Consultation Response from KC Highways		
2019/90155 Former Harrisons Electrical Warehouse, Huddersfield Road, Dewsbury, WF13 2RU		
Change of Use and alterations to convert trade counter retail unit to function room		
Date Responded: 09/12/19	Responding Officer: CNB	Responding Ref: K15-2NW/40
POST DEFERRAL FURTHER INFORMATION RESPONSE This response is based on further information submitted by the applicant after a meeting at Kirklees planning offices on 4/11/19 and after the application was deferred at committee for further information relating to highways issues and should be read in conjunction with the previous highways responses, amended below. These comments refer to Technical Note 4: Highways and Parking/Event Management Plan by VIA Solutions and drawing No 1816203a Proposed Car Park Layout. The initial highways concern was that the impact of the proposals on the operation of the local highway network and highway safety could not be assessed as there were no trip generation figures provided with the application to indicate the vehicular demand that the development would create. There are no trip generation figures for this type of land use on the national TRICS database, the i

Ground Floor Plan As Proposed
Scale 1:100
0m 1m 2m 3m 4m 5m

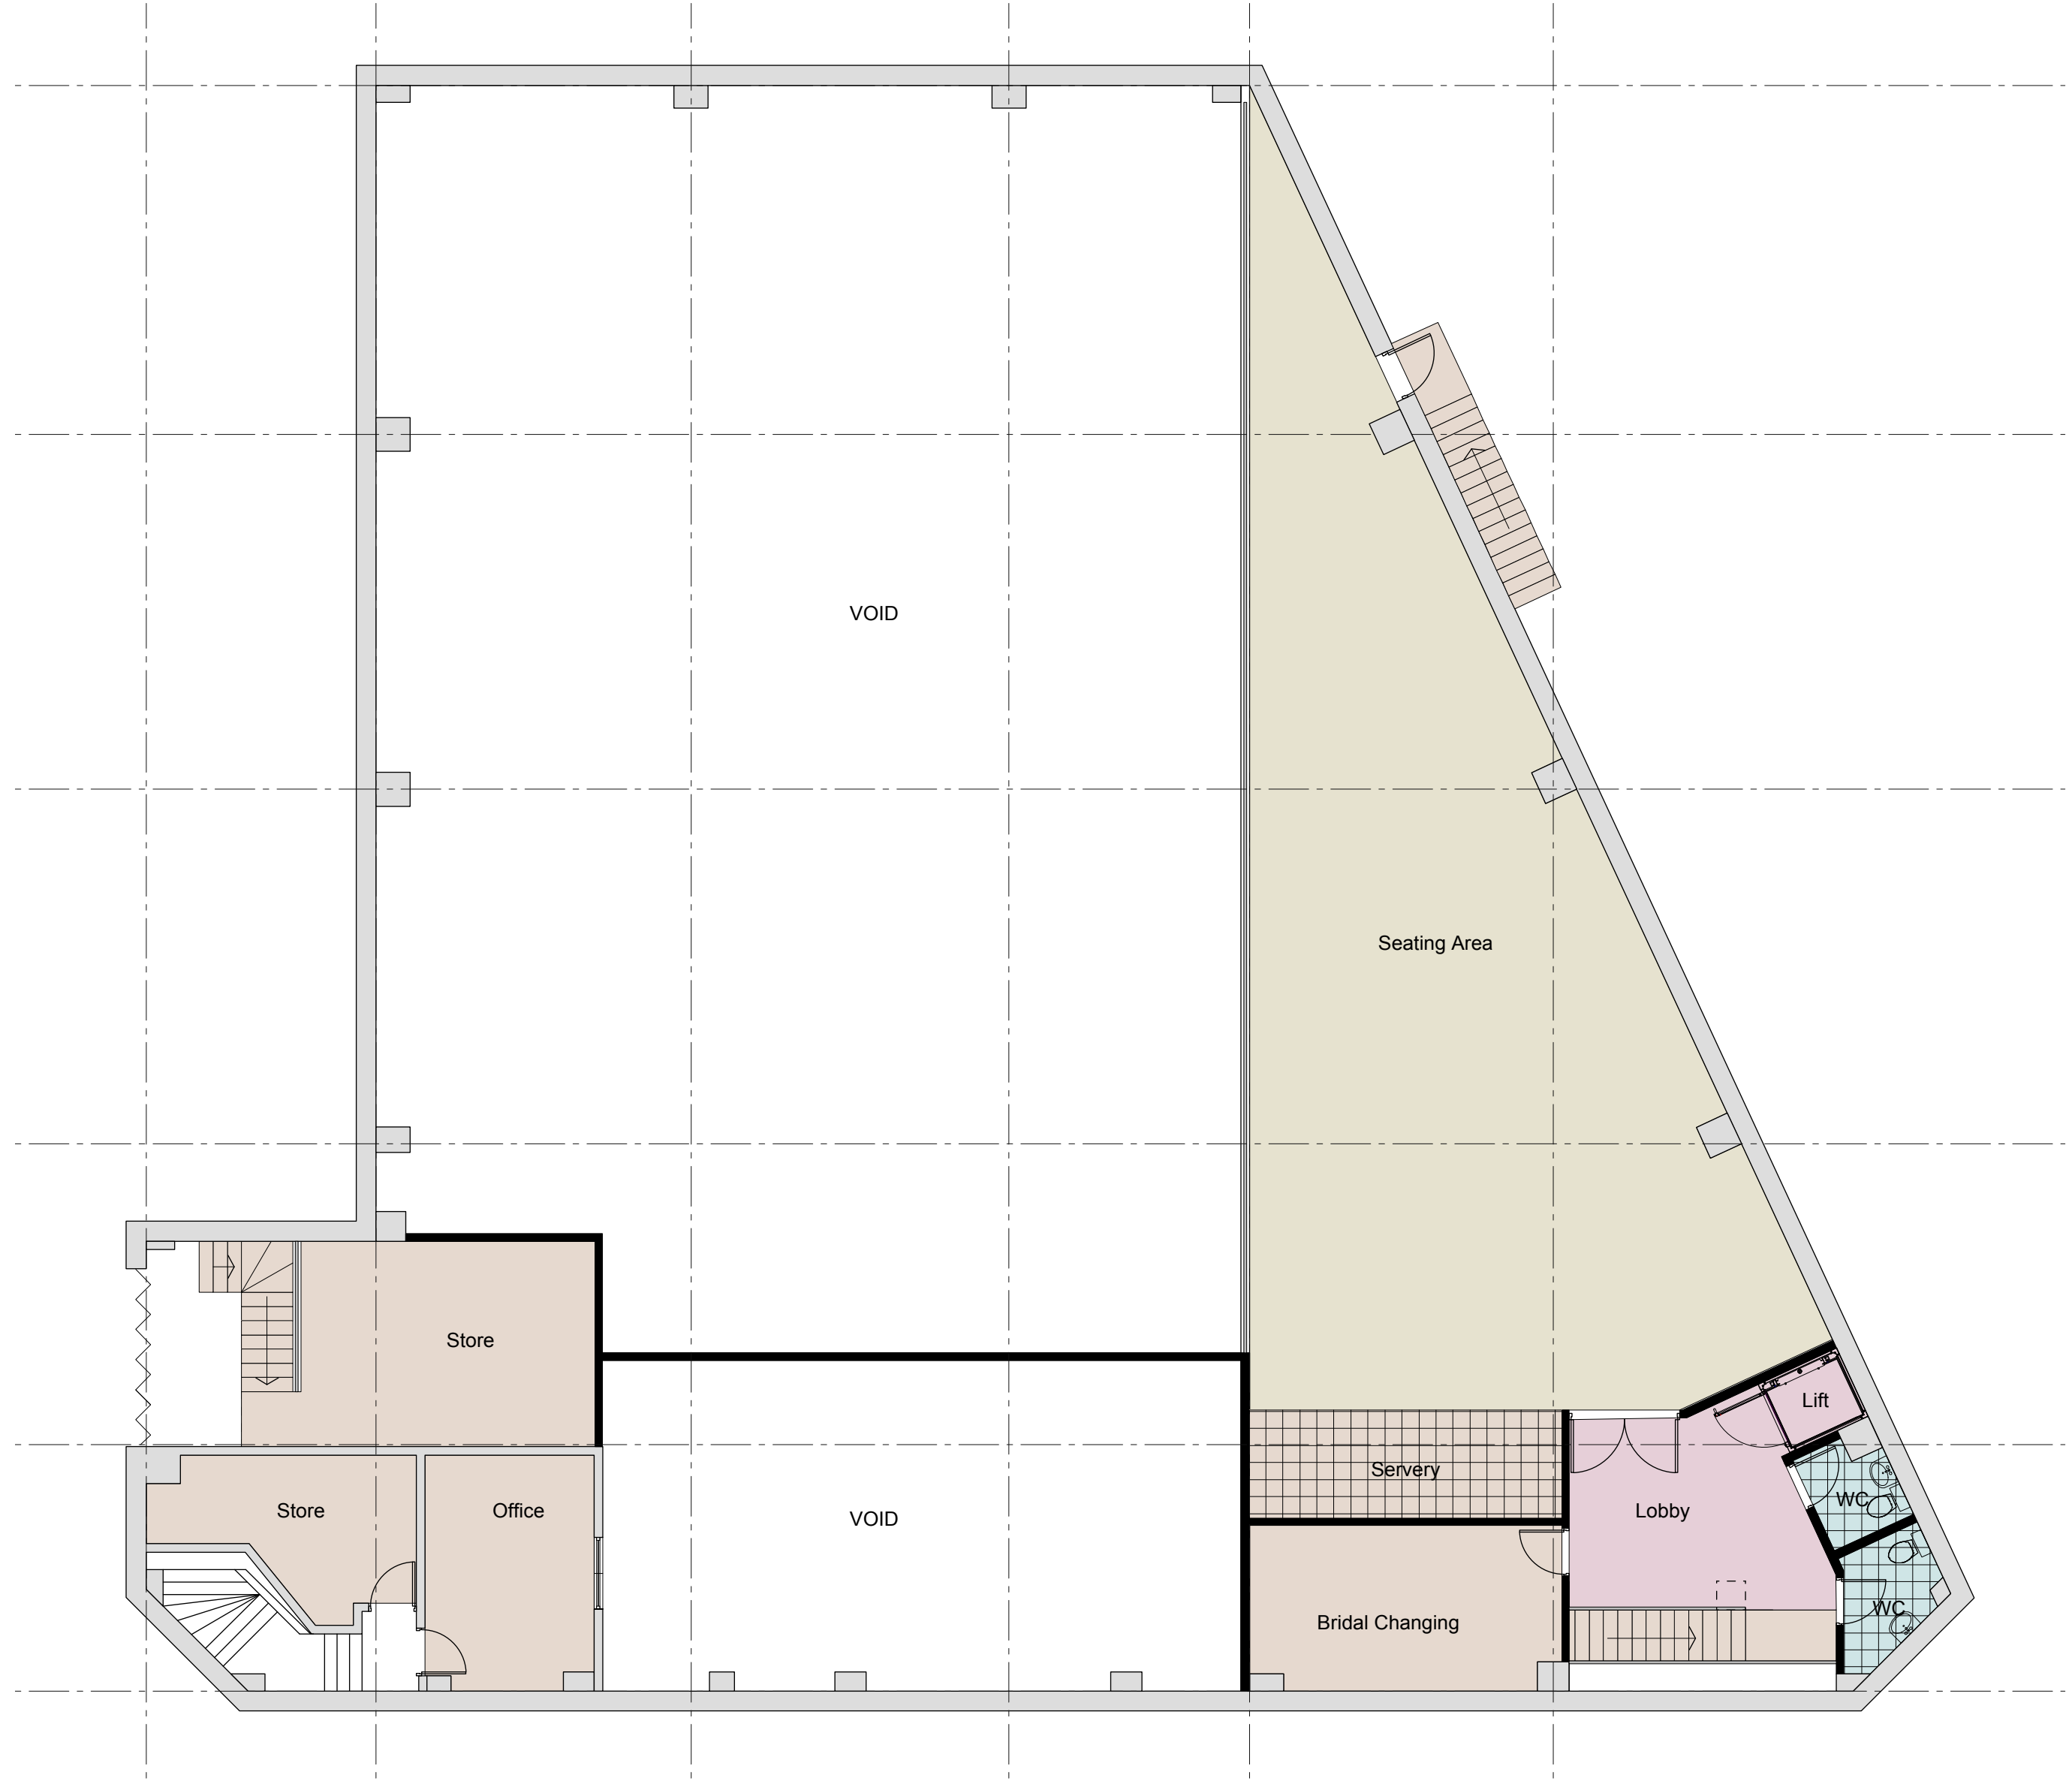
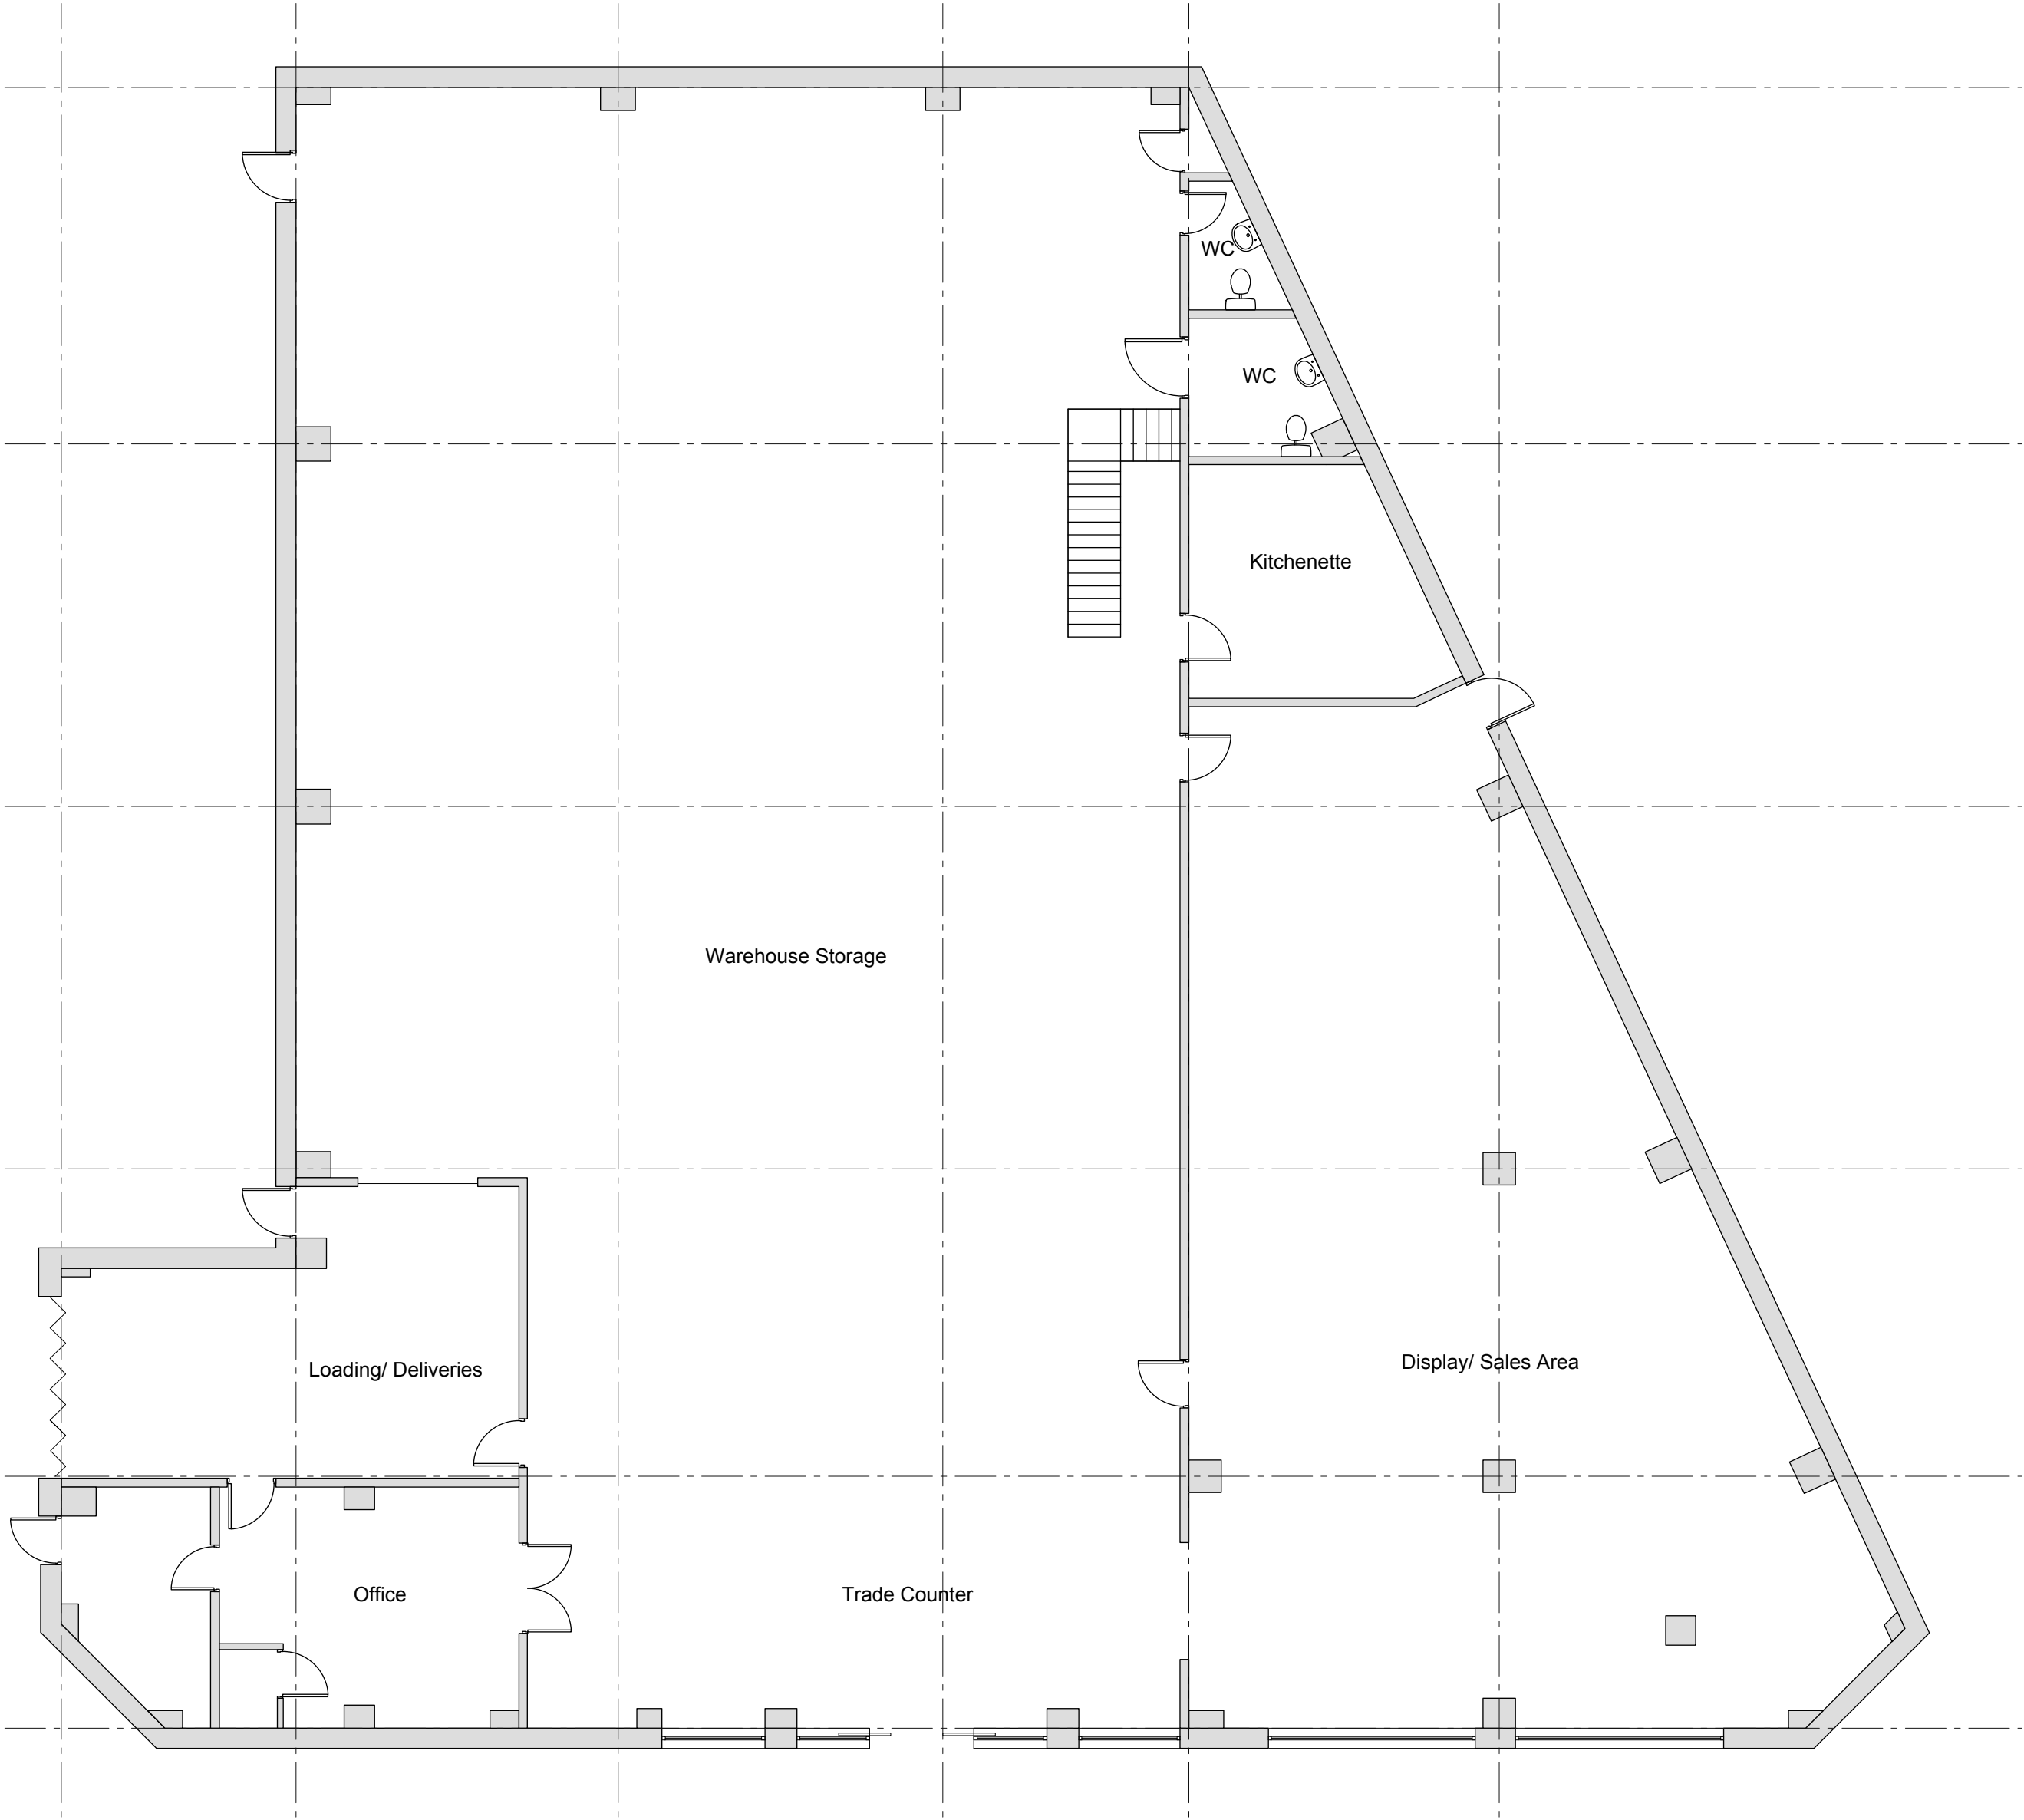
The application is to change a former electrical services trade counter and warehouse into a banqueting centre of approximately 550sqm of public dining floor area over two levels using a mezzanine floor above the main floor (measurements scaled from drawing 18-144-11). The application proposes 34 parking spaces to the front of the building with access from A683.
